From: Clear, Gwen (ECY) <GCLE461@ECY.WA.GOV> on behalf of ECY RE CRO SEPA COORDINATOR <CROSEPACOORDINATOR@ECY.WA.GOV>
Sent: Thursday, February 19, 2015 3:39 PM
To: Jeff Watson
Subject: Comments for CU-14-00003
Attachments: 3870 One Energy Development LLC.pdf

Re: CU-14-00003

Thank you for the opportunity to comment during the optional determination of nonsignificance process for the construction and operation a 13.6 acre photovoltaic solar power generation facility on approximately 112 acres, proposed by One Energy Development LLC. We have reviewed the documents and have the following comments.

PLATE 11

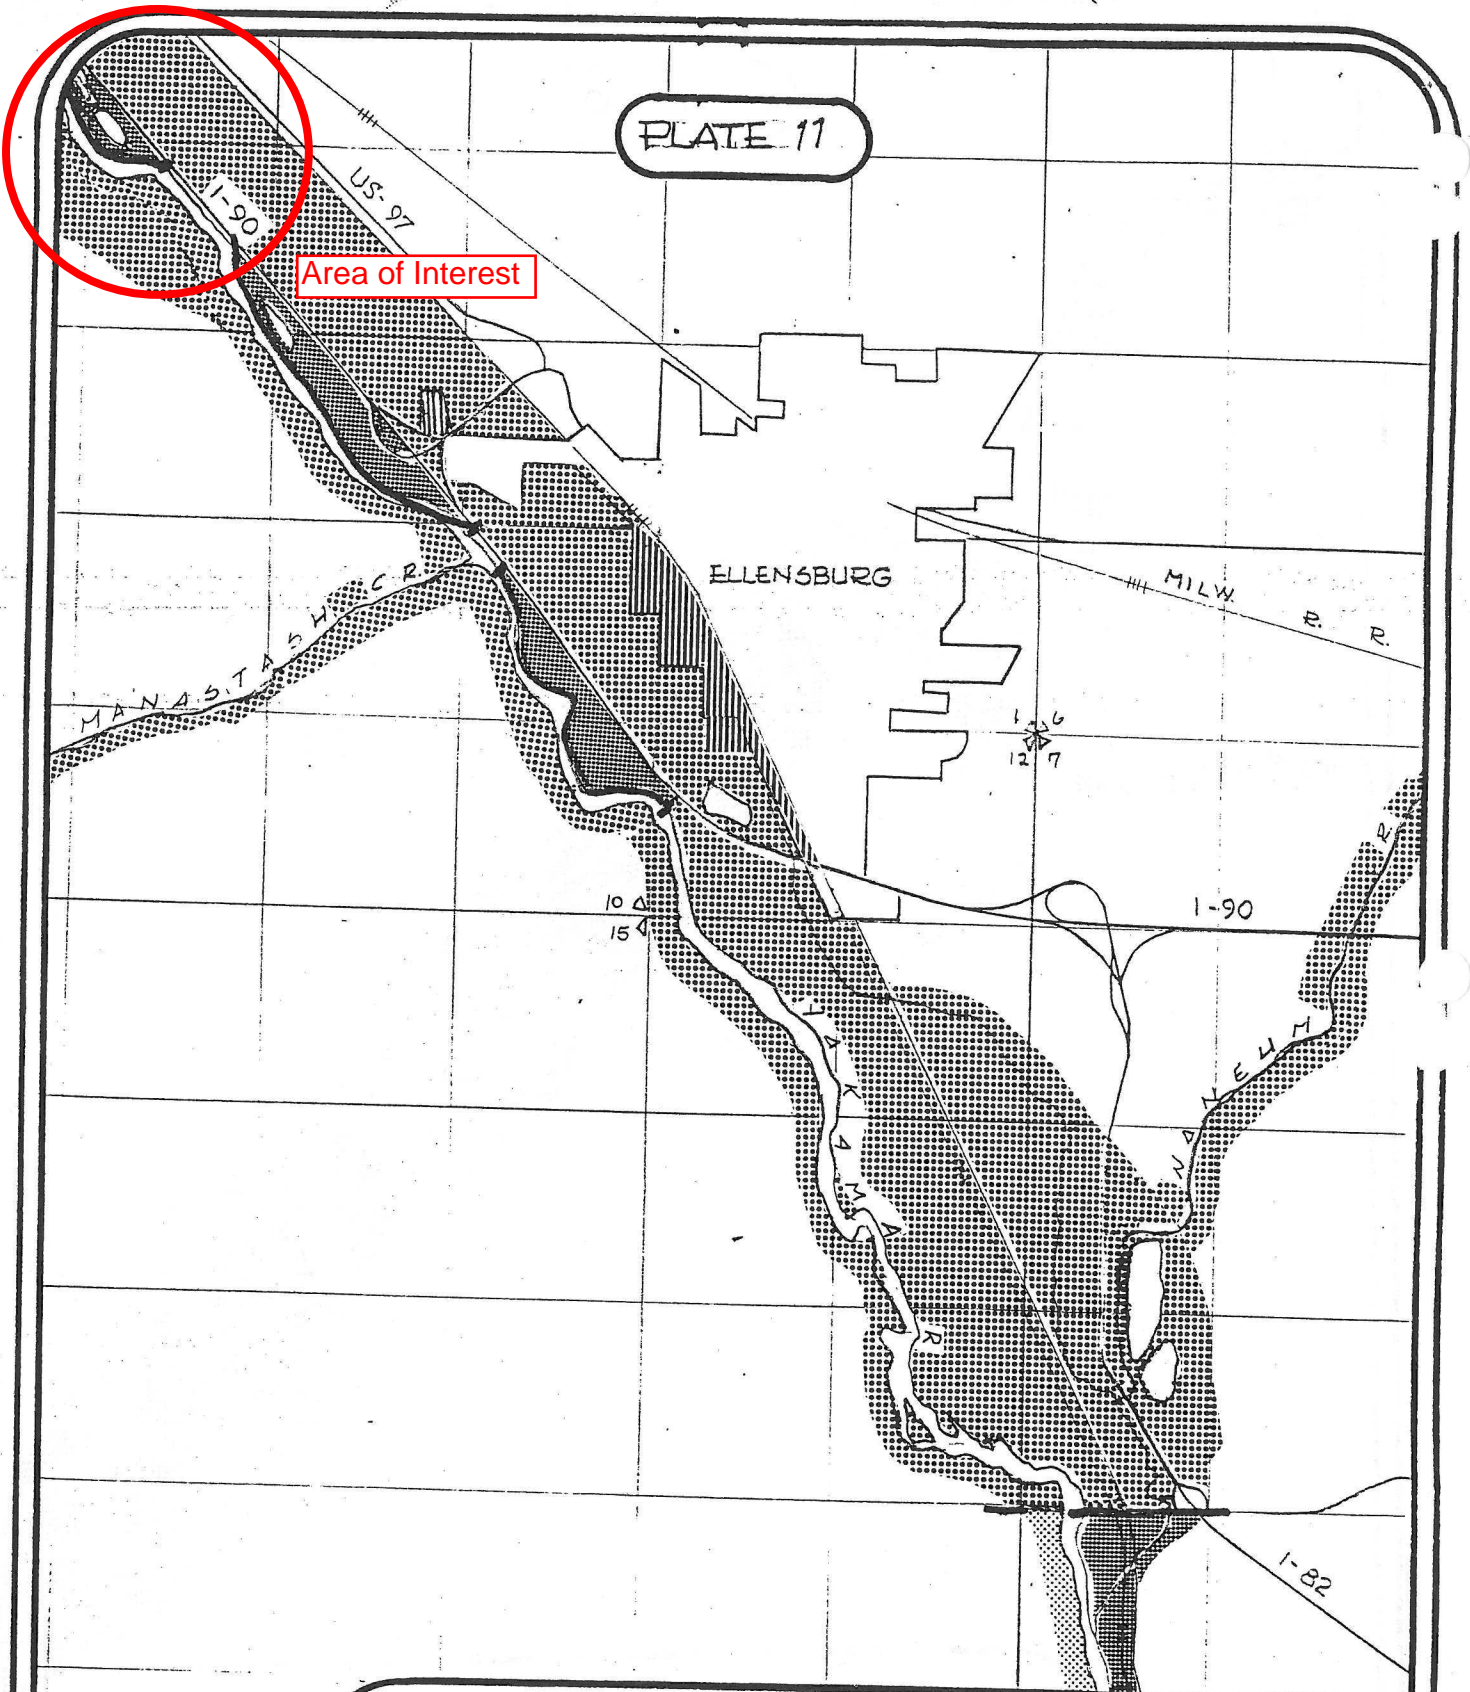
The SEPA checklist states that the project is located within a Rural shoreline environment. Solar panels are stated as being used to run a security light and electricity meter: Production of power for on-site agricultural and domestic purposes would not create a change in use. However, the amount of energy produced for offsite use (if any) should be described. If the majority of power would be produced for off-site use, then the development may need to be also be evaluated as a Shoreline Commercial Use development as well as a Shoreline Utility Use when processing the shoreline permit. Commercial developments are not allowed in Rural Shoreline environments (Kittitas County Shoreline Master Plan, section 23 (3)). It is not clear from The Kittitas Shoreline Master Plan language whether a Shoreline Conditional Use Permit issuance could address that issue.

STORMWATER REPORT

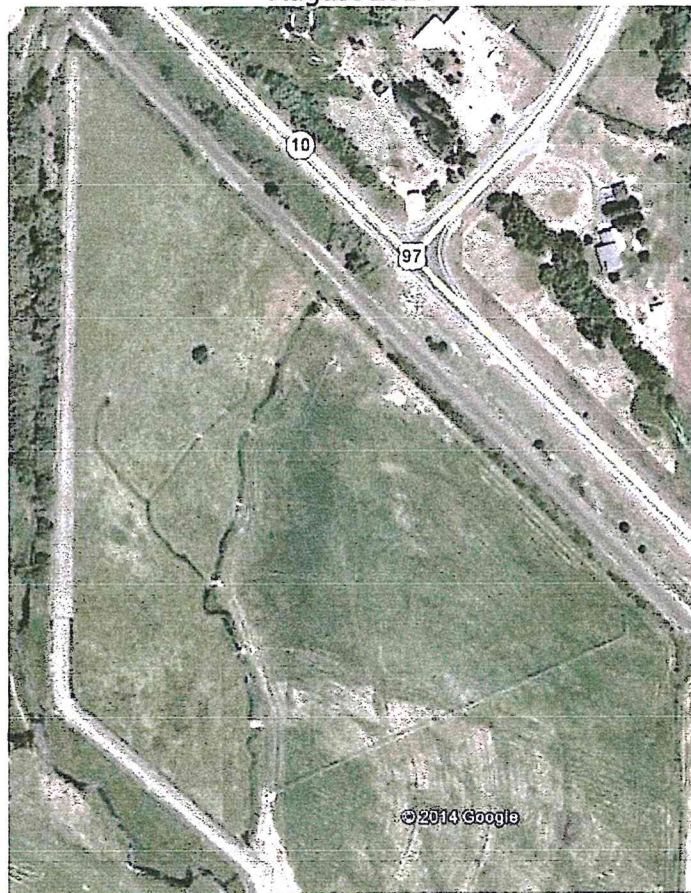
Information regarding the stormwater management plan states that infiltration will be directed into a "vegetated buffer". Use of wetland buffers for stormwater infiltration must be consistent with the Stormwater Management Manual for Eastern Washington (EWSM). **The applicant should provide a text narrative in the shoreline permit filing documents which describes how the routing of the stormwater in the proximity of wetlands will be consistent with the EWSM.**
